Mortdale State Significant Development Application Response to Submissions Report

APP Corporation Pty Limited

April 2017

Site Plan

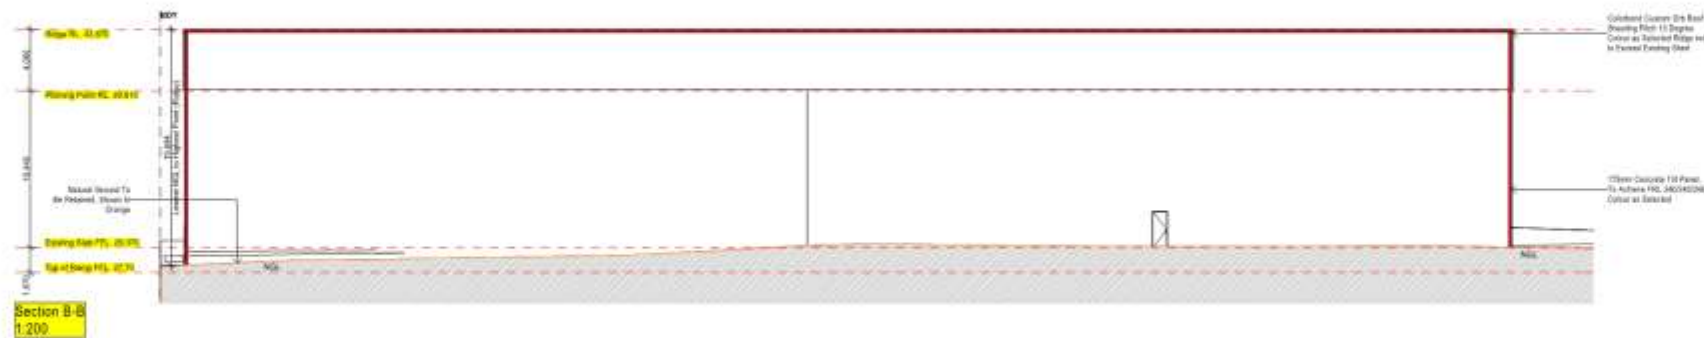
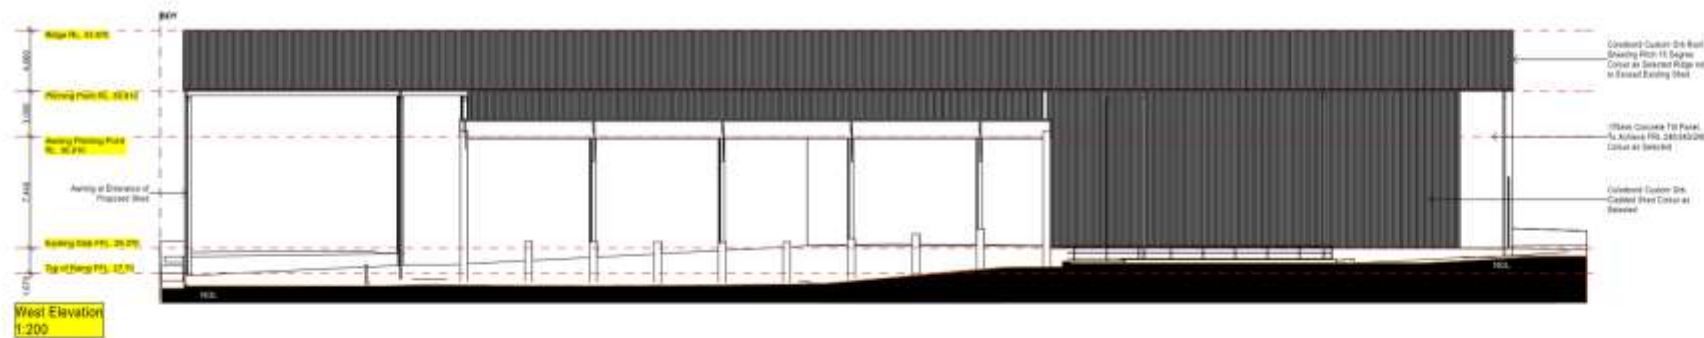
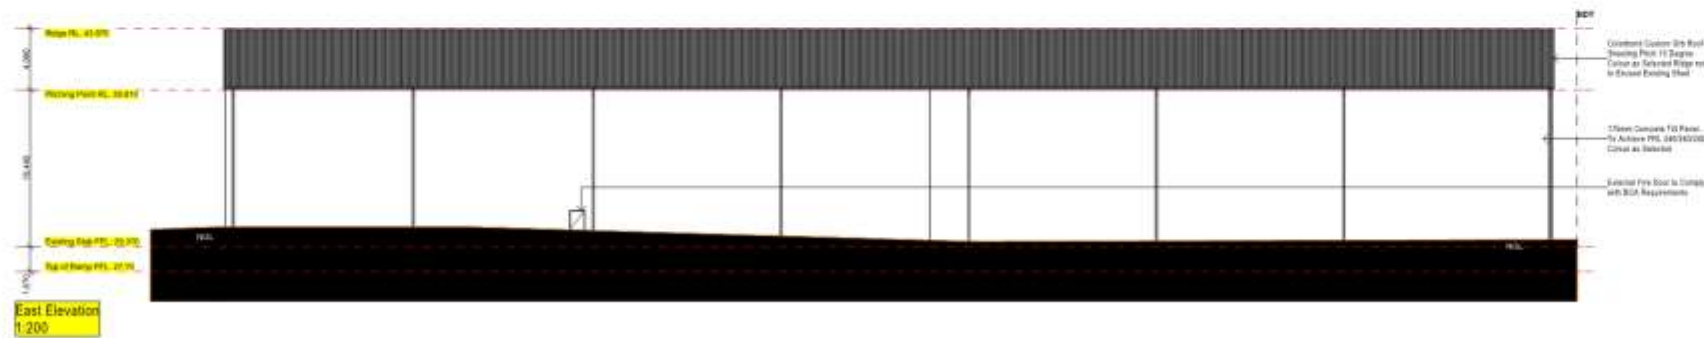
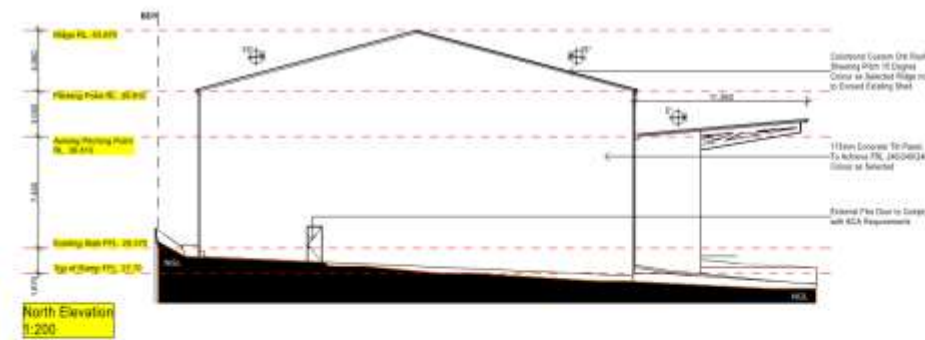
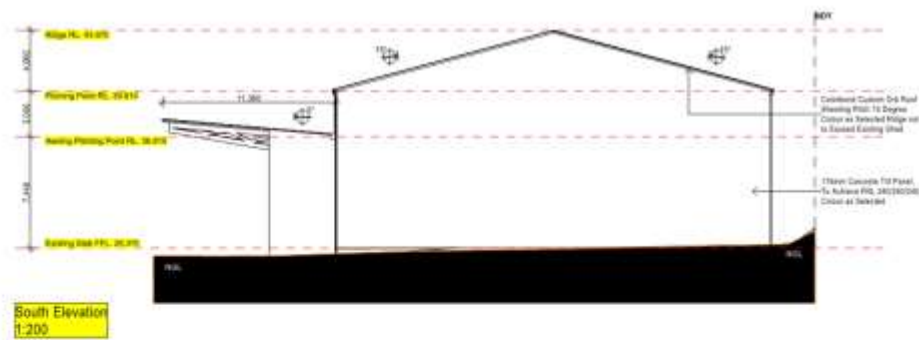
- A full assessment of the (FSS) is required to be undertaken by FRNSW pending approval;
- Does not support the proposed location of hydrant booster assembly and attack fire hydrants nor does the fire hydrant system meet the requirements of FRNSW;

SLR prepared a revised fire safety plan attached to this report which identifies alternative locations for the booster and the attack hydrants as well as a response to the matters raised by FRNSW. SLR recommend that the necessary detailed design and calculations should be prepared as part of the final design. A site meeting would then be held with FRNSW and the proponent's fire safety consultant to finalise the design. This meeting will seek to satisfy FRNSW requirements and resolve any outstanding issues. SLR concluded that the matters raised by FRNSW have been sufficiently addressed for the purpose of assessing the SSD application.
